Application No: FP/54/26/AG  
Site Address: Rabbit Island Rear of 84 Brooks Lane Bognor Regis PO22 8DN  
Description of works: Prior approval under Schedule 2, Part 6, Class A for the creation of a new agricultural track.

**OBJECTIONS TO PERMITTED DEVELOPMENT APPLICATION FP/54/26/AG**

Revision:			
address Lands off Brooks Lane Felpham, Felpham, Bognor, PO22 8DN			
project Proposed track			
title Existing Location Plan			
scale 1:1250 on A3	date Dec 2025	dwg no. 2025.485.01	revision

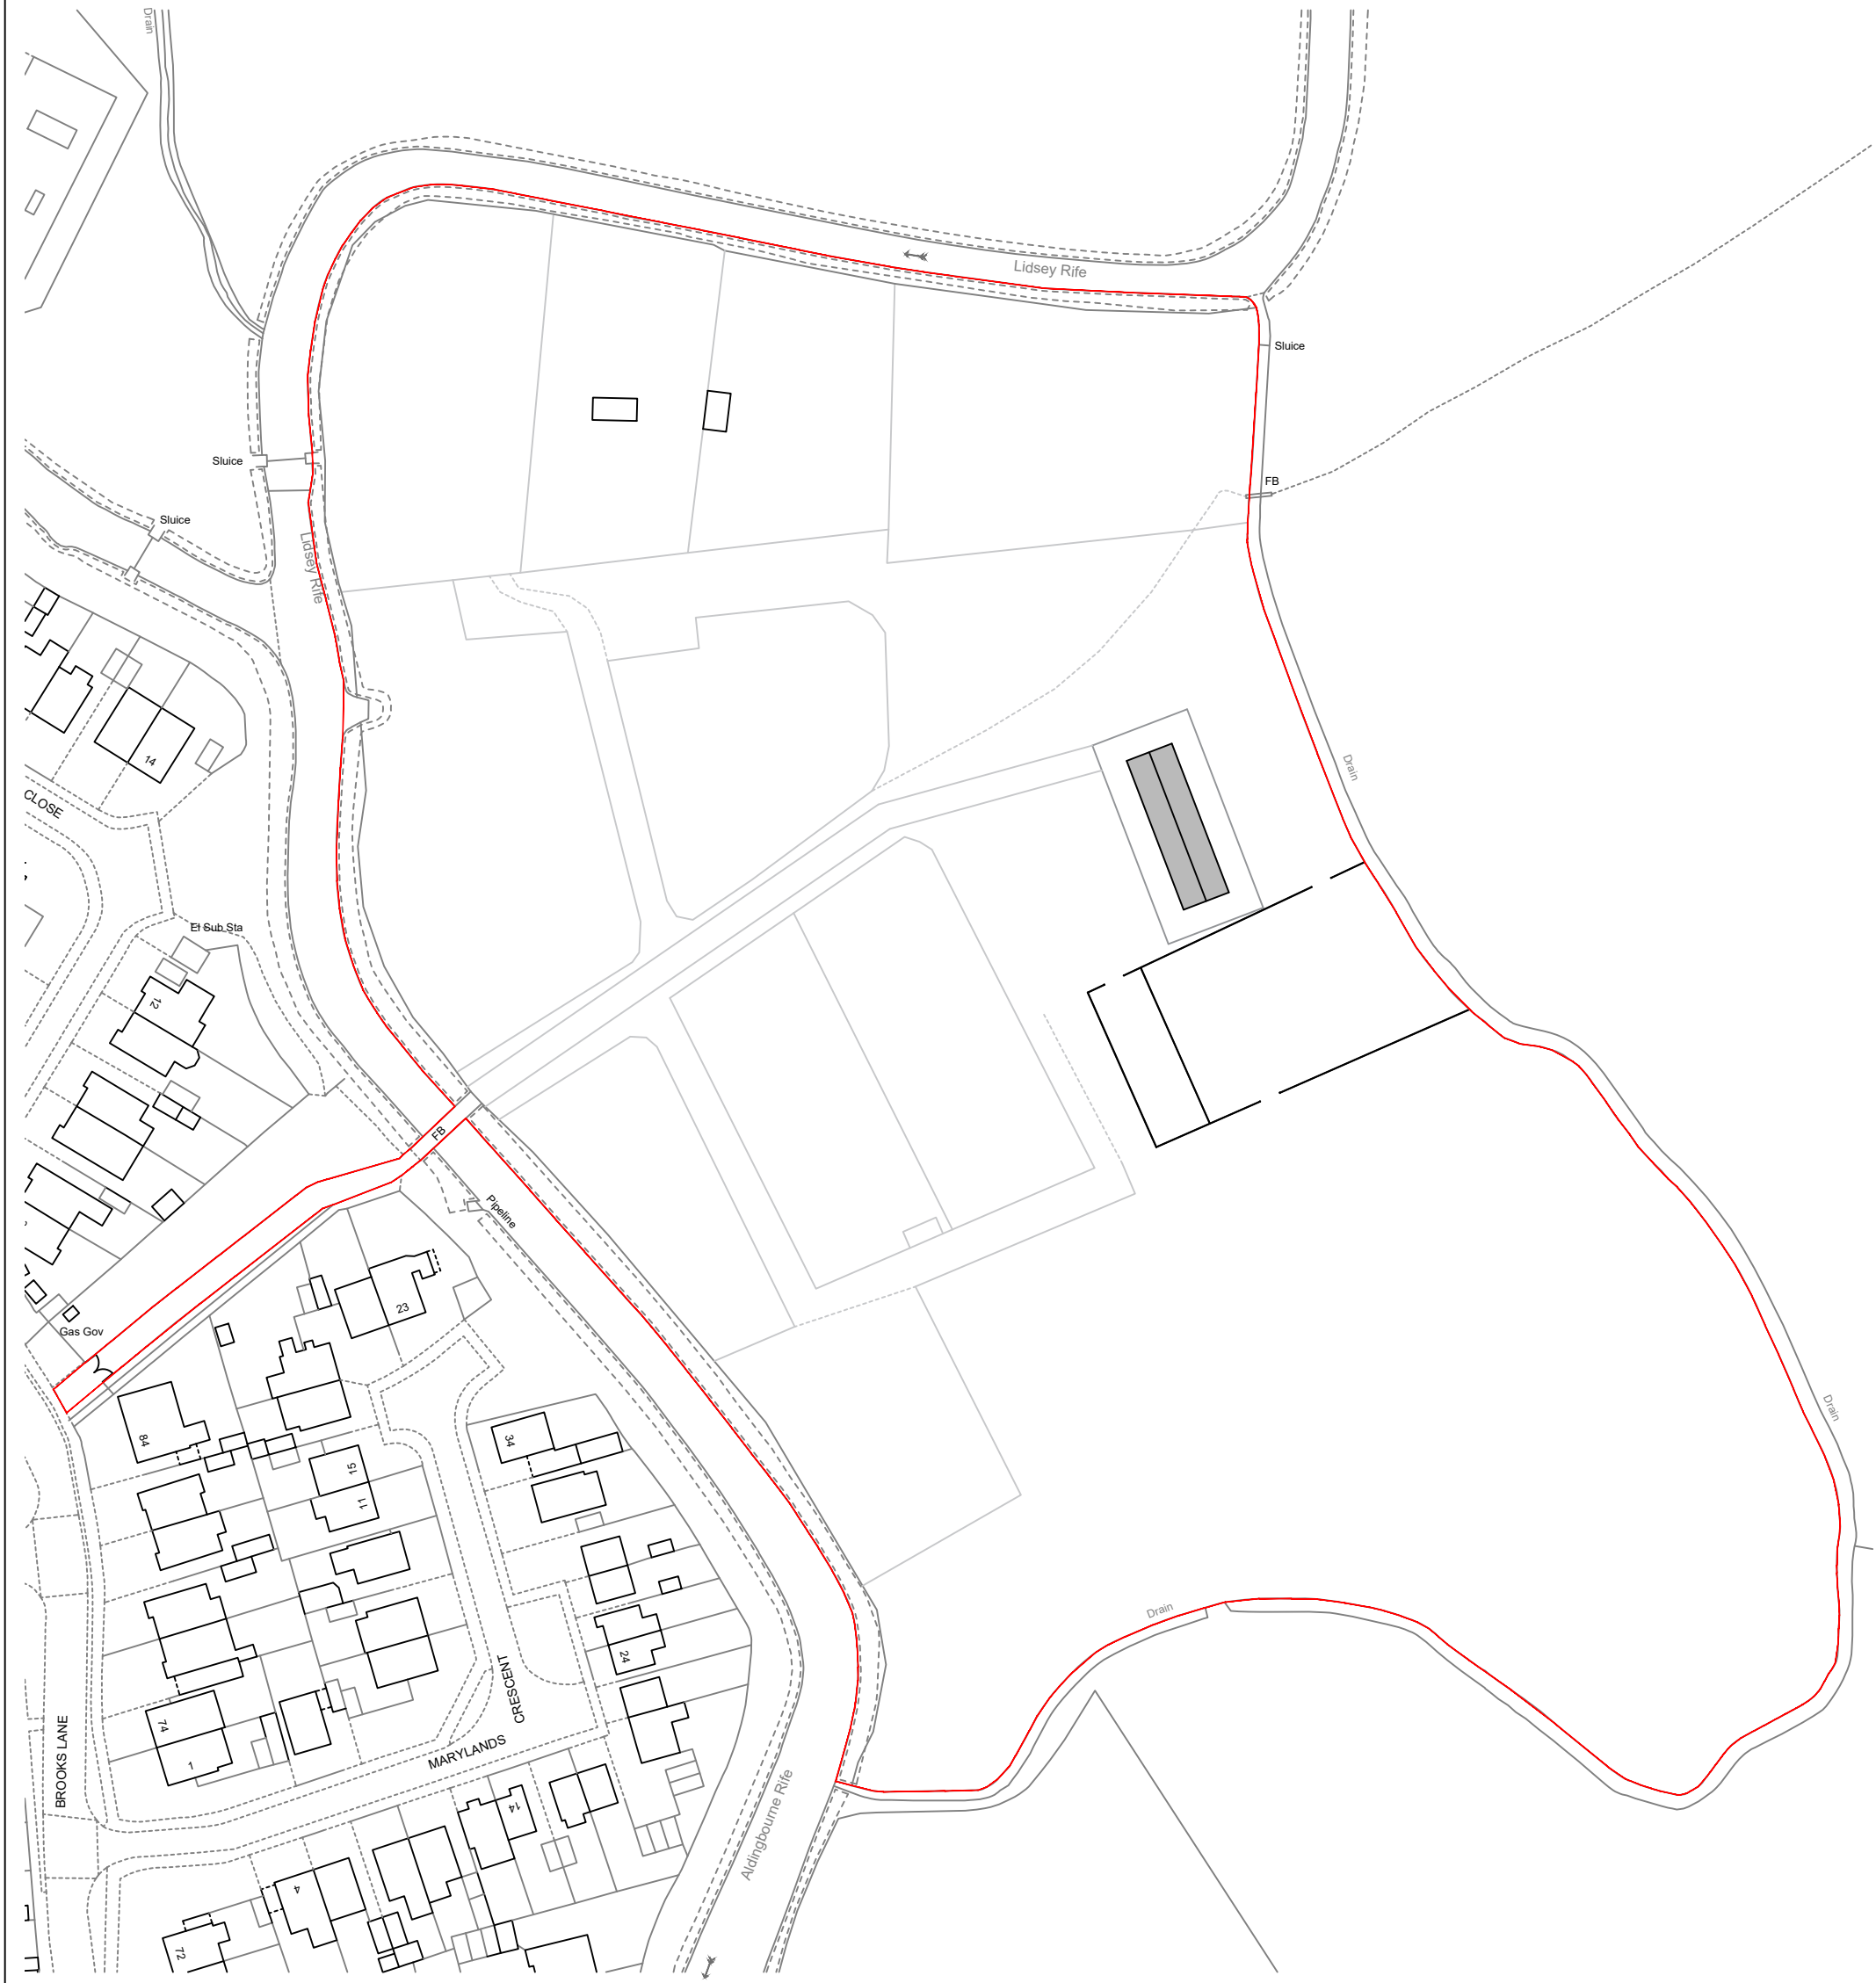
The author appears confused as on Page 3 the site is 5.2ha but on Page 7 it is 5.43 - is this another "Trivial matter"?

On Page 10, the author highlights that the application must be accompanied by a written description of the proposed development - he has done so regarding the track but there is no description or suggested use or need for the Hardstanding mentioned on the title page. It is not mentioned in the Proposal on Page 6 or labelled on the diagram. What size is it and what is its "agricultural" purpose?
